Environmental Assessment Exhibition (Epping Park) - MP 08_0257 and MP 08_0258

Thank you for the opportunity to provide input on the Environmental Assessment for the Major Project Applications (MP 08_0257 stage 1, residential development and MP 08_0258 Early Works Package) as submitted by the Sydney Broadcast Property Pty Ltd at 61 Mobs Lane, Epping.

The External works plans for Mobbs Lane (Drawing 7587-PA-21 to 7587 – PA-25) has been assessed based on current and potential operations of State Transit, design detail and general comments have been provided:

Title	MOBBS LANE EXTERNAL WORKS PLAN SHEET 4 OF 5
Drawing No.	7587-PA-24
Issue	D
Cad File No.	7587-PA-21
Xref(s)

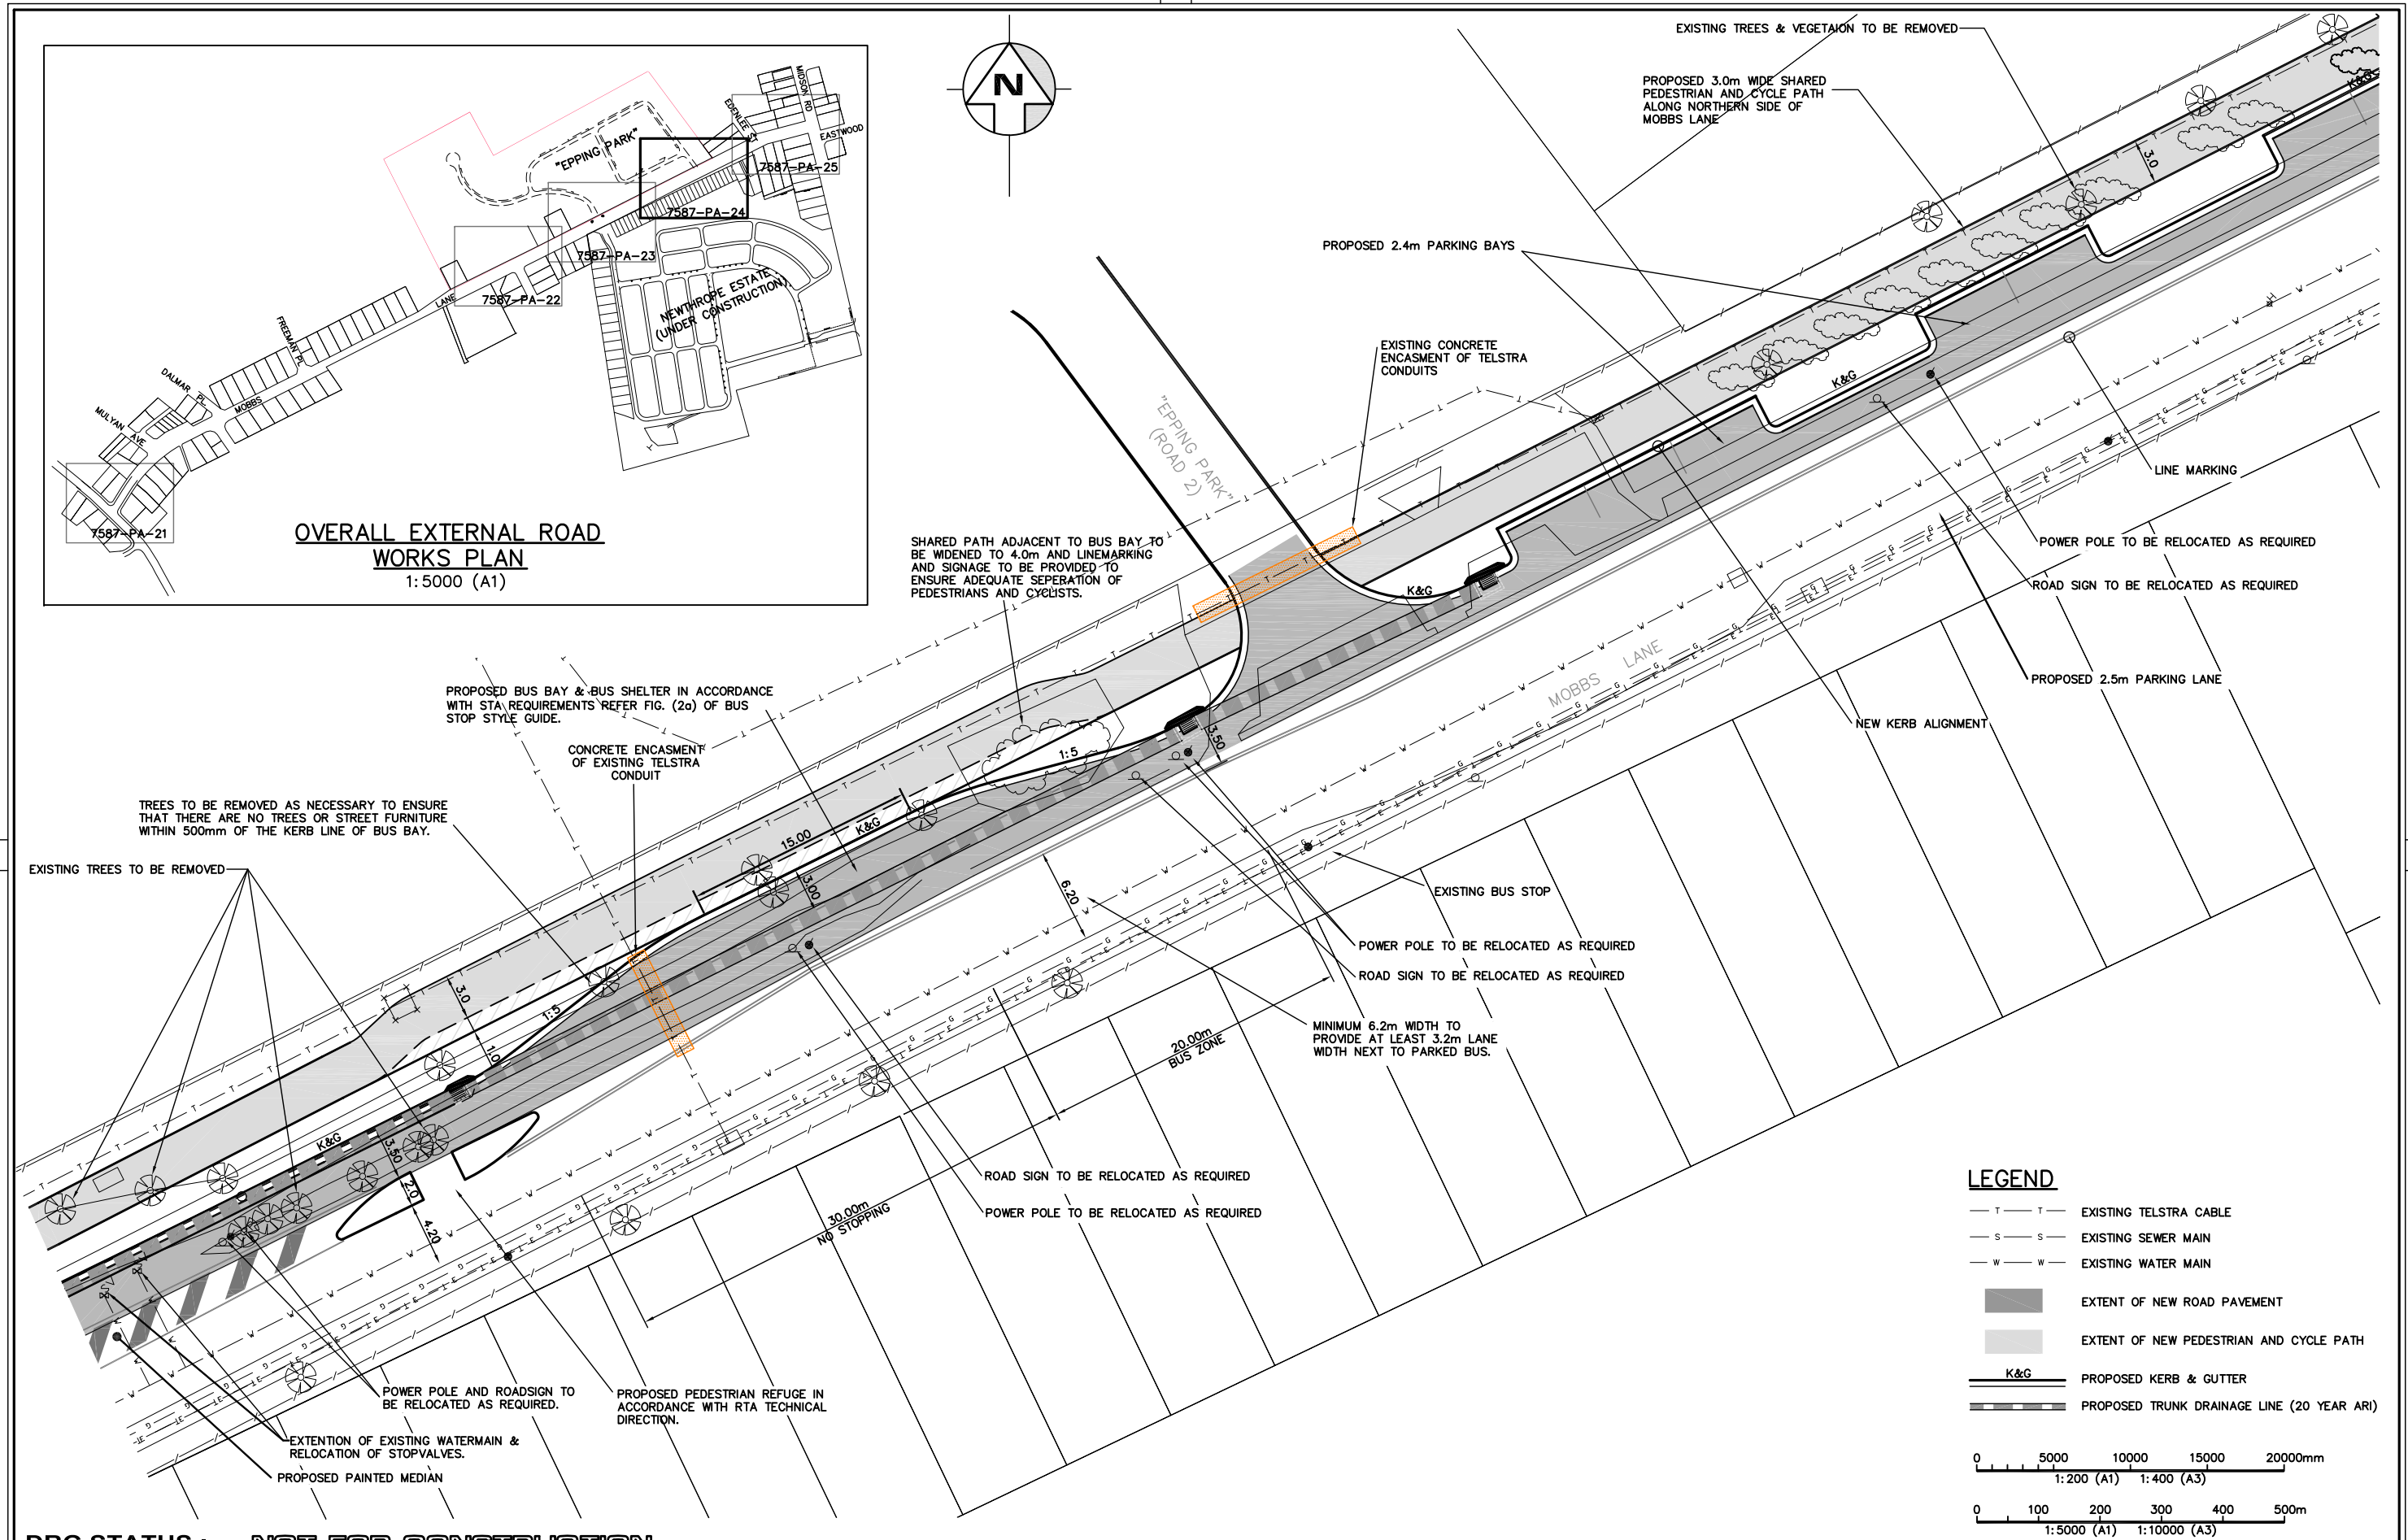
Drawing Number (7587-PA-24). The location of the proposed bus bay adjacent to the entry/exit for road two onto Mobbs Lane could create potential conflicts. To alleviate this difficulty, the bay would need to be relocated to the departure side of the entry/exit from road two; this would allow no stopping on the approach to the bay and would reduce conflicts associated with manoeuvring. This bay has also been noted as shelter provided, but this was not clear on the plans and no shelter location was found when viewing the plan.
